**RE: Maverik – Gibson
Grading & Drainage Plans
Engineer's Stamp Date: 12/22/23
Hydrology File: M15D021D**

RE: Plan Review – Maverik Yale & Gibson - Plan Review Comment Responses

MAVERIK STORE
2121 YALE BLVD SE
ALBUQUERQUE, NEW MEXICO
GRADING PLAN

MAVERIK STORE
2121 YALE BLVD SE
ALBUQUERQUE, NEW MEXICO
GRADING PLAN

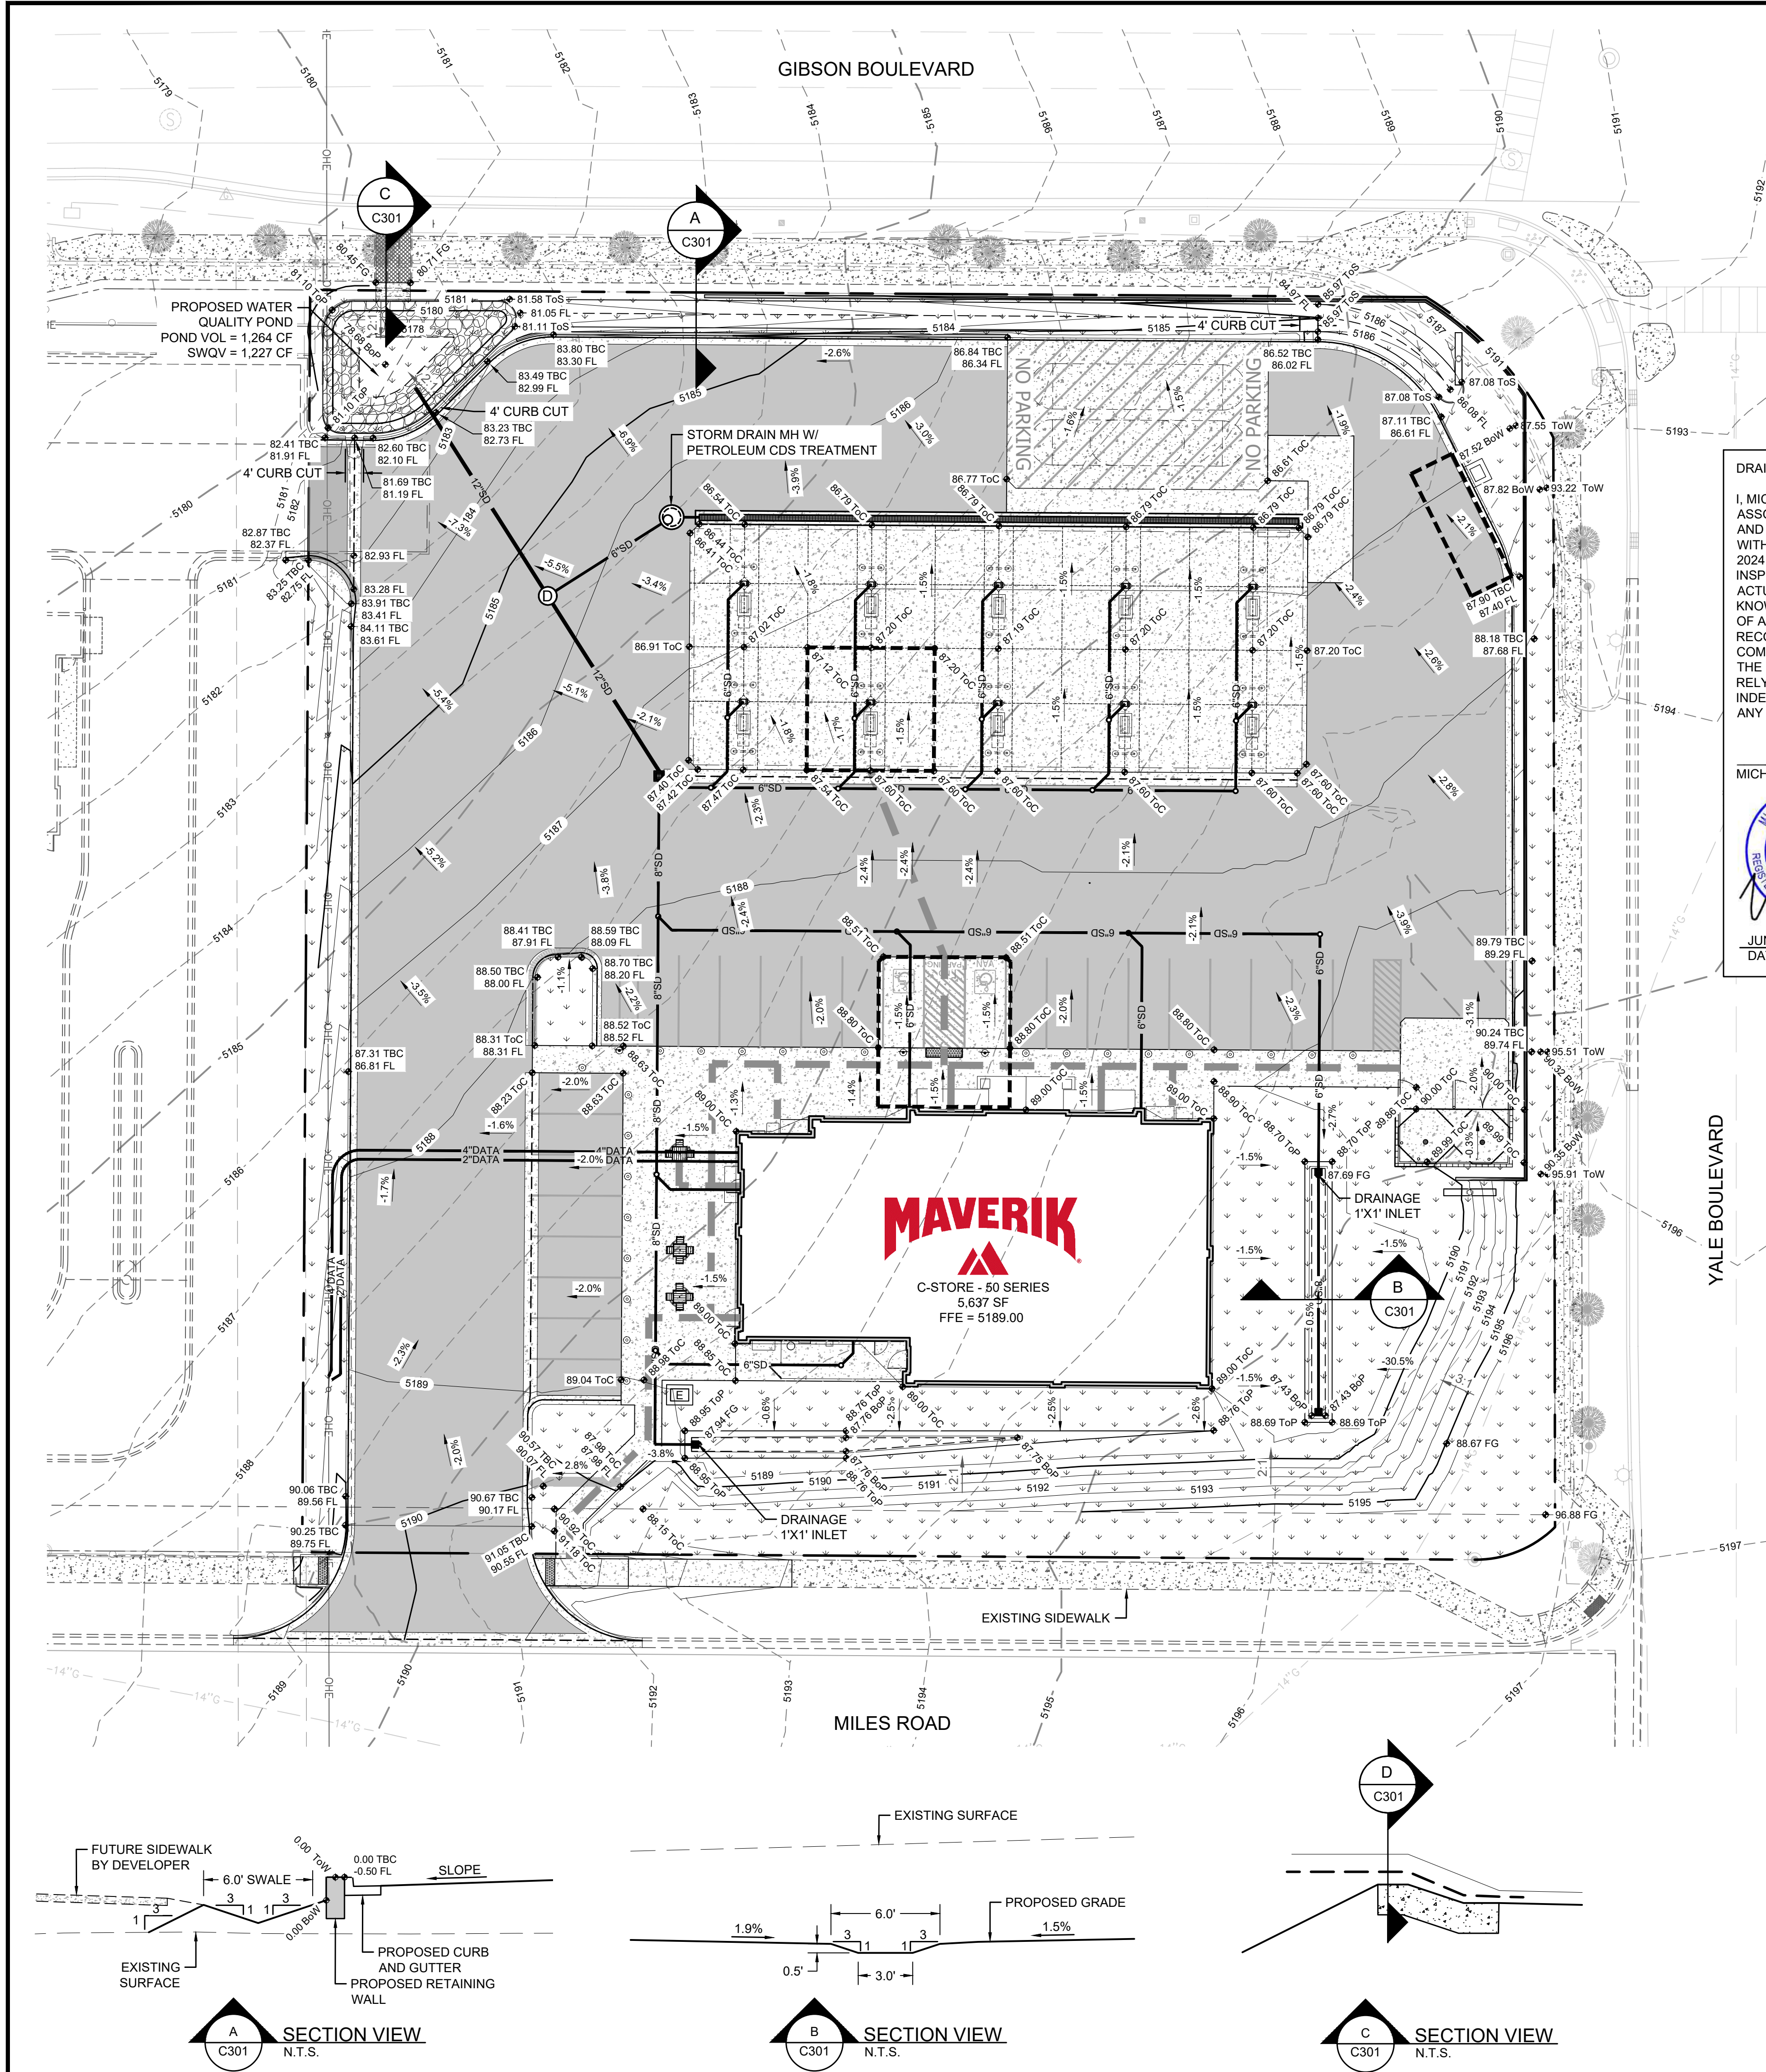
1. *There appears to be a layer turned off for the existing curb & gutter within Gibson & Yale.*
a. Layers for the existing site have been turned on or unfrozen.
2. *All gas stations must drain to an oil/water separator (the Owner's choice) prior to discharge. This appears to drain into a manhole prior to going into the stormwater quality pond. Please label this manhole as an oil/separator.*
a. Point labels have been rotated to show the CDS manhole and has been labeled.
3. *Please use the latest SO-19 Notes (Attached).*
a. Light pole design has not been provided.
4. *Label "PROPOSED SIDEWALK CULVERT 7.5' X 17", to be modified as Existing.*
a. Label has been changed from Proposed to Existing.
5. *Plans need to be stamped with a full date (month\day\year, this is how they reference it).*
a. Plans have been stamped and dated as requested.
